**STATE SIGNIFICANT DEVELOPMENT:
Section 96(1A) Modification Application**

***One Carrington Street (formerly known as
'City One'), Sydney***

SSD 5824 MOD1

Environmental Assessment Report
Section 96(1A) of the *Environmental Planning
and Assessment Act 1979*

project
 Wynyard Place
 drawing
 Proposed Elevation A (East)
 scale
 1 : 250
 status
 drawing no.
 DA2100
 drawn
 paper size
 A1
 checked
 PS/JL
 issue
 project no
 m: 958 a: 120298.00
 Rev 02

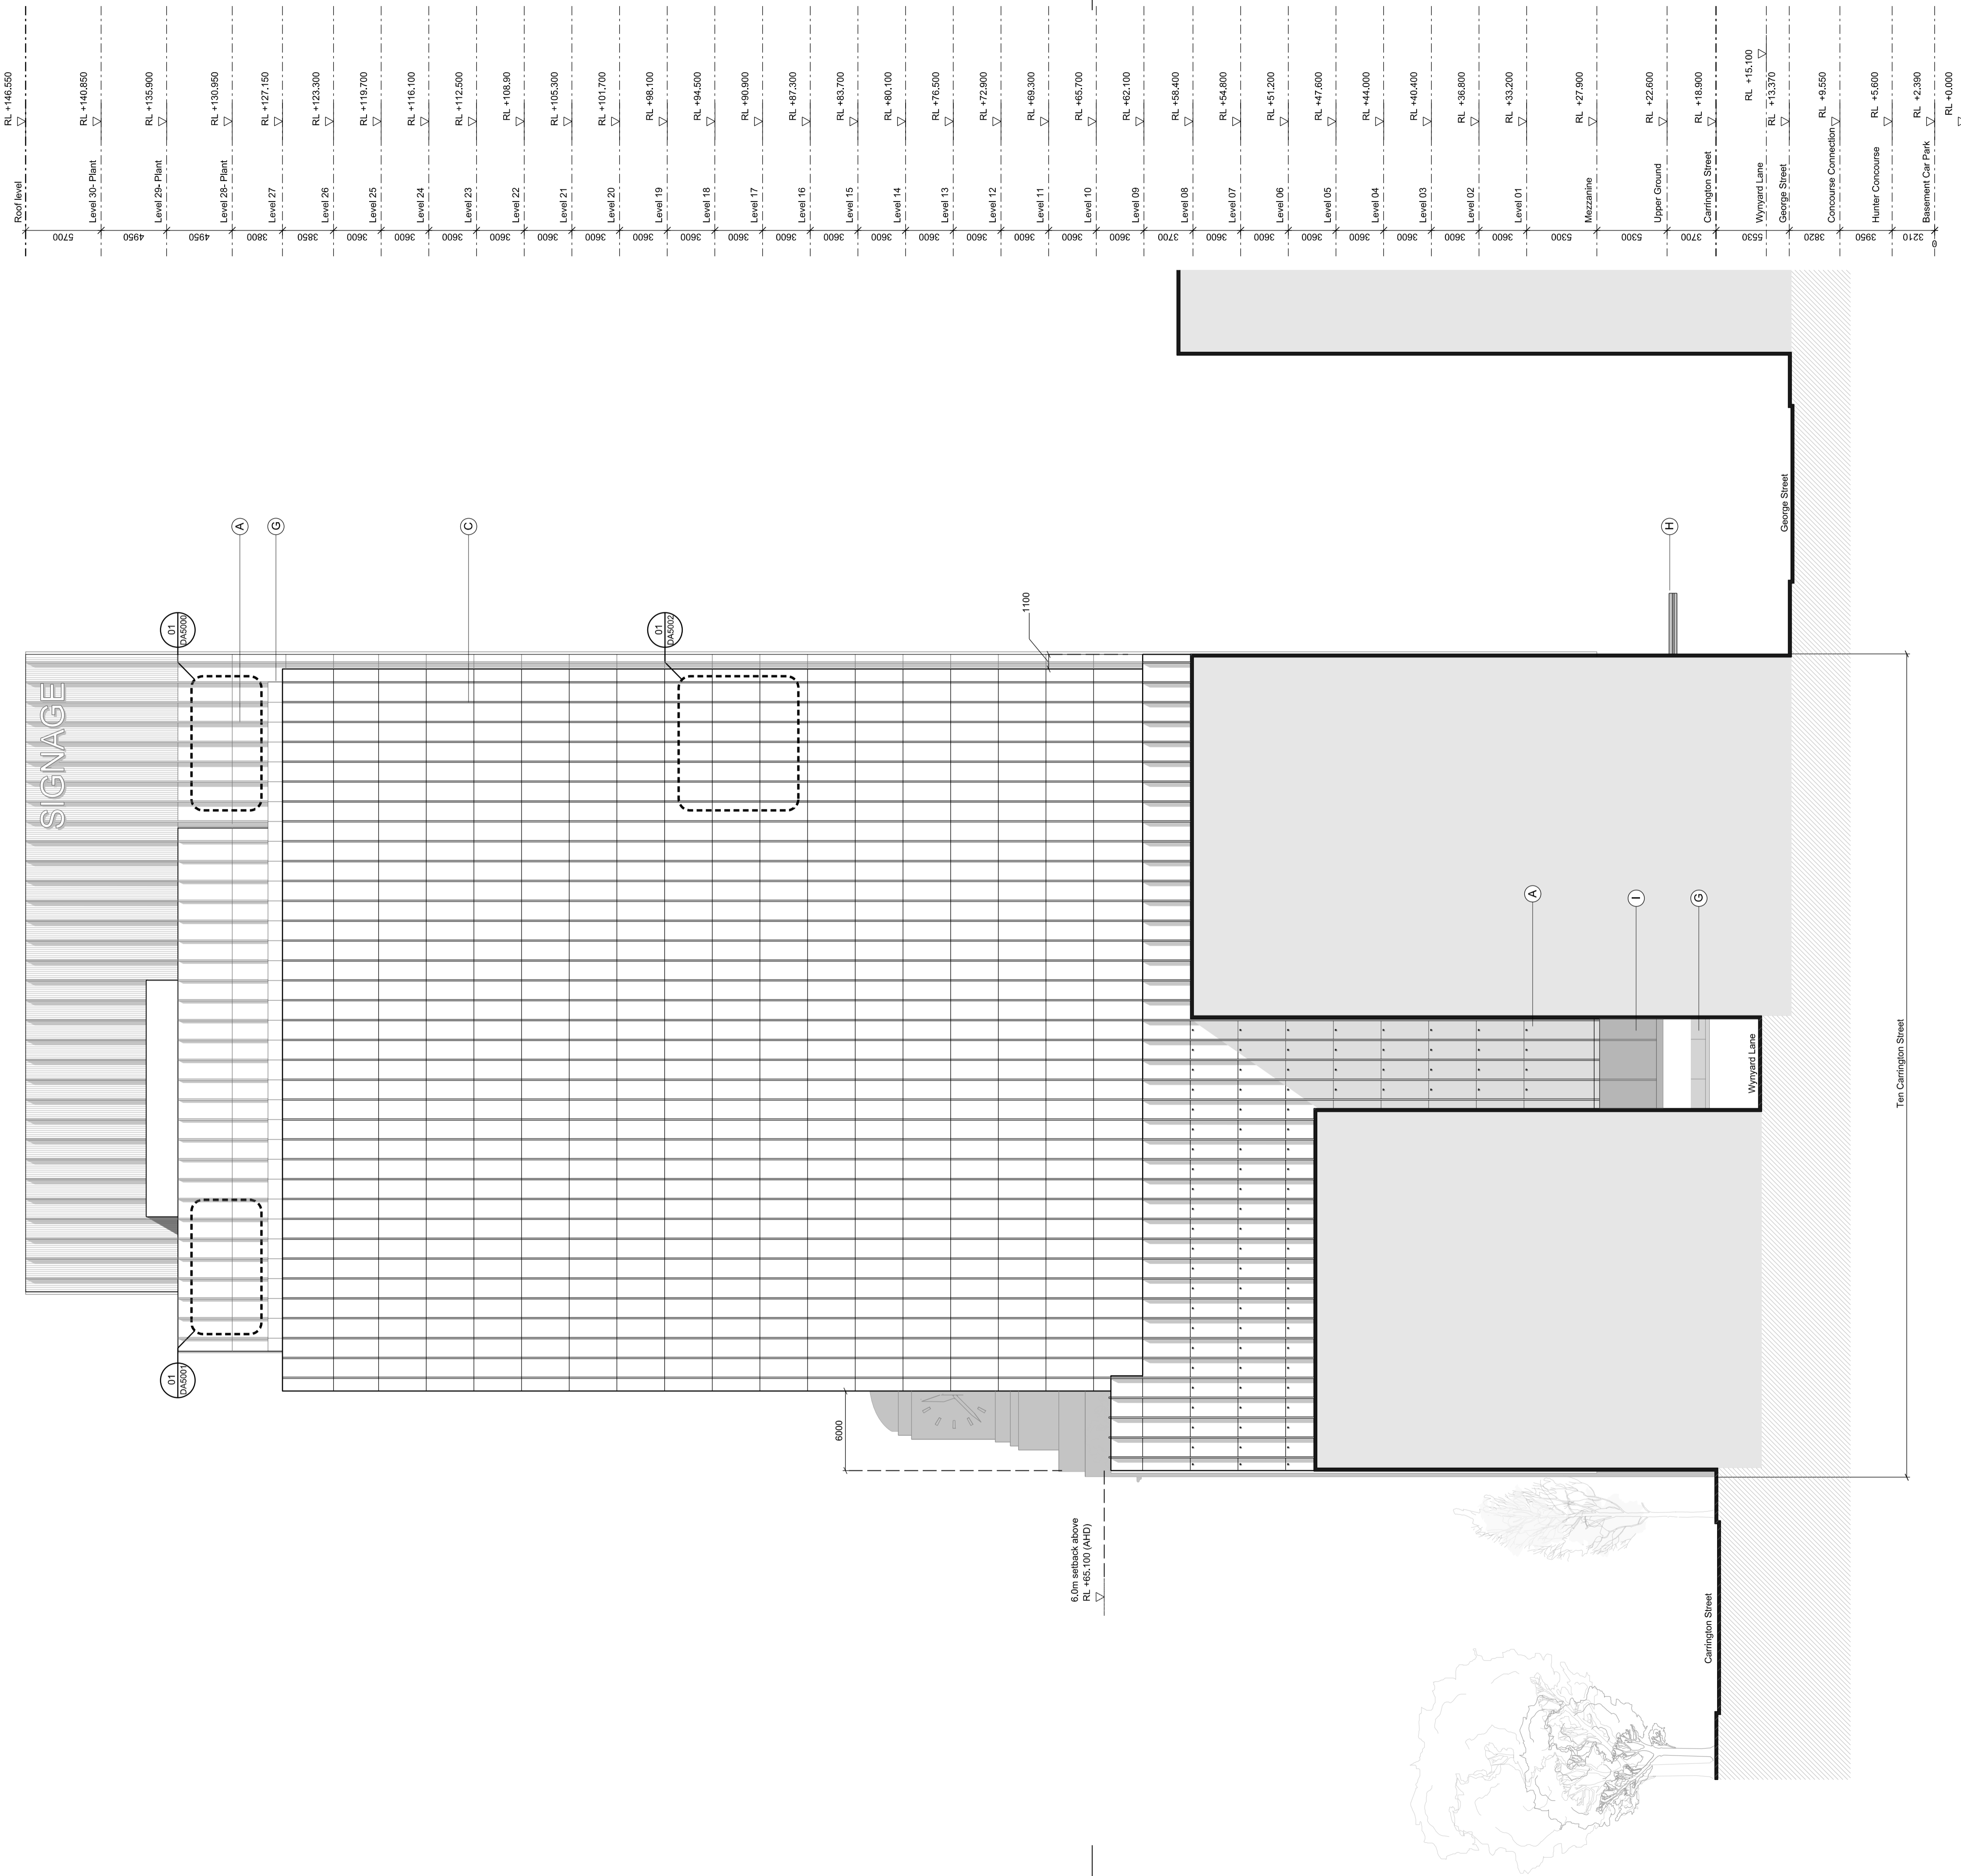
The Department requested further clarification of the amended tower façade composition and particularly justification for the reduction in the depth of the proposed projecting fins.

The proposal amends the tower façade composition by providing three (instead of two) vertical fin depths of 15mm, 100mm and 200mm (Figure 5).

The Department considers that the proposed amendment in the façade treatment is acceptable as:

- the revised fin depths emphasise the three distinct interlocking built form components on both the George Street and Carrington Street facades and therefore strengthen the articulation of these elevations;
- the 15mm fin/capping provides a fine grain articulation to the facades, which integrates the overall materiality and architectural approach. The 15mm fin/cap also provides a visually lighter weight cladding, which adds additional visual interest to the overall appearance of the tower; and
- the reduced fin depth to the podium (300mm to 200mm) is minor in nature and would not be noticeable from a pedestrian perspective. The modification will maintain a suitable level of visual solidity to the podium elevations / base of the tower.
